Subject: FW: Application_Ref_No=WA/5/18/PO

Arun District Council has received application: **WA/5/18/PO** for
Application to discharge a planning obligation dated 11/01/2016 under planning
application WA/27/15/PL relating to Affordable Housing Contributions within the
Section 106 Agreement
at Deans Yard Orchard Way Walberton

Site Location Plan

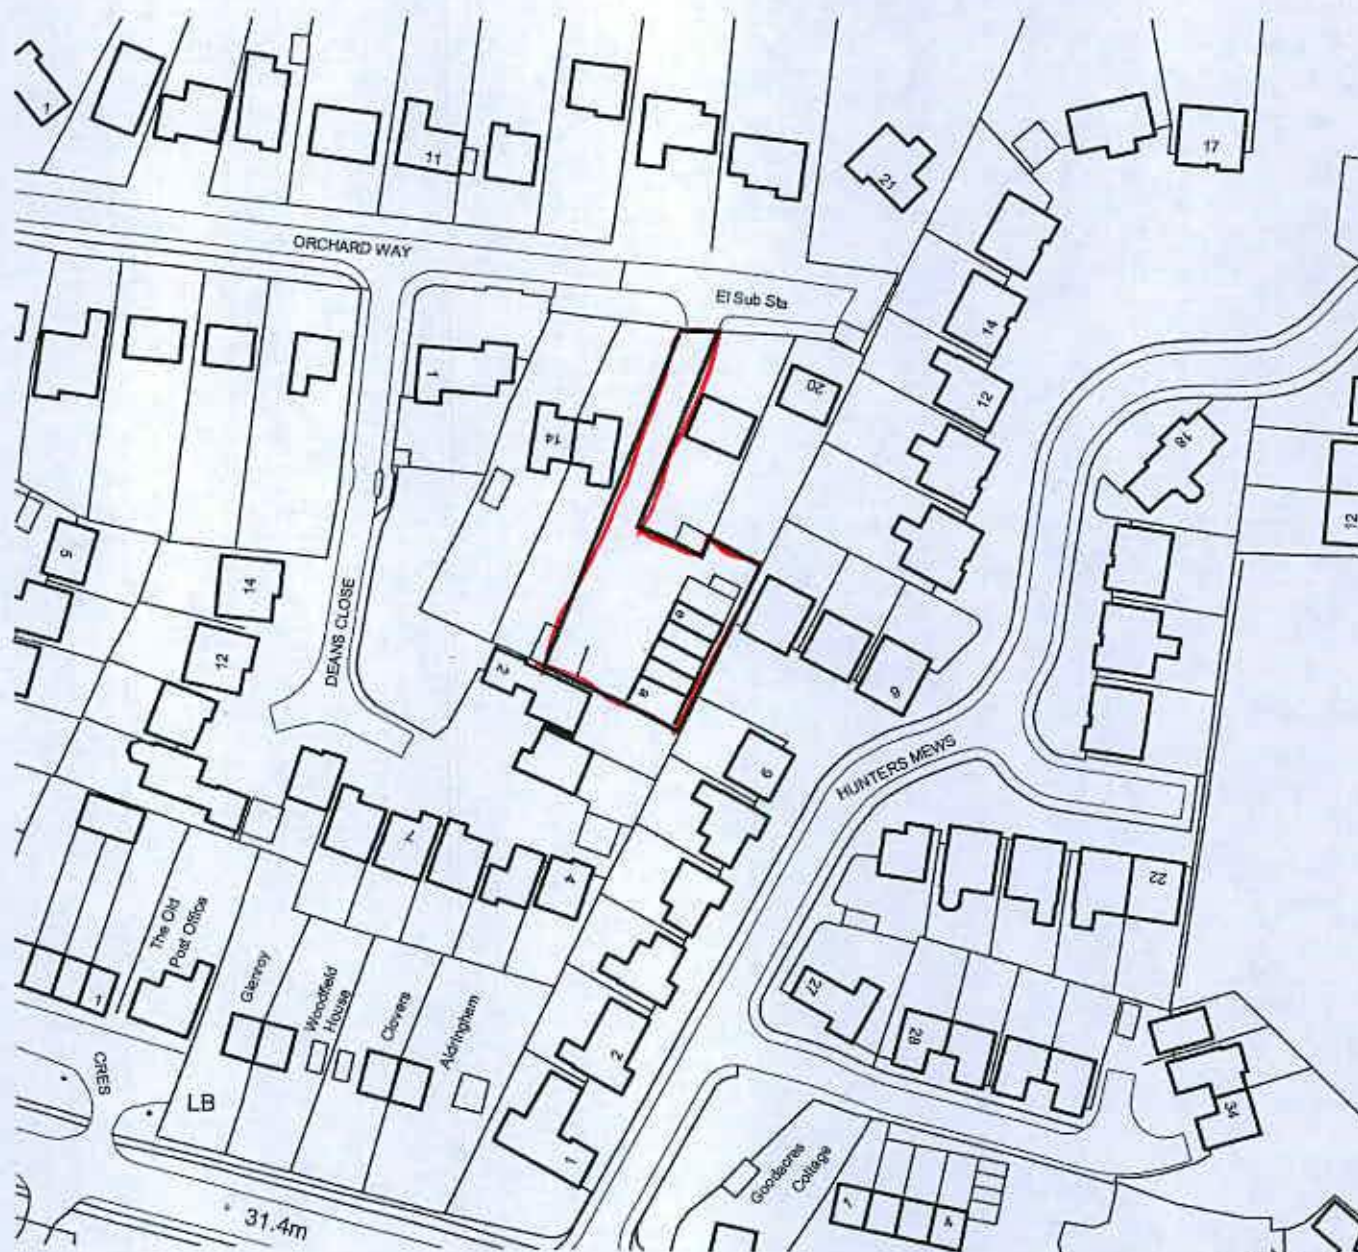
We would like to bring to your attention that the site plan of the application is incorrect and part of the plan is the property of 20 orchard way which is the rear drive and garage to this property (See Title deed attached).
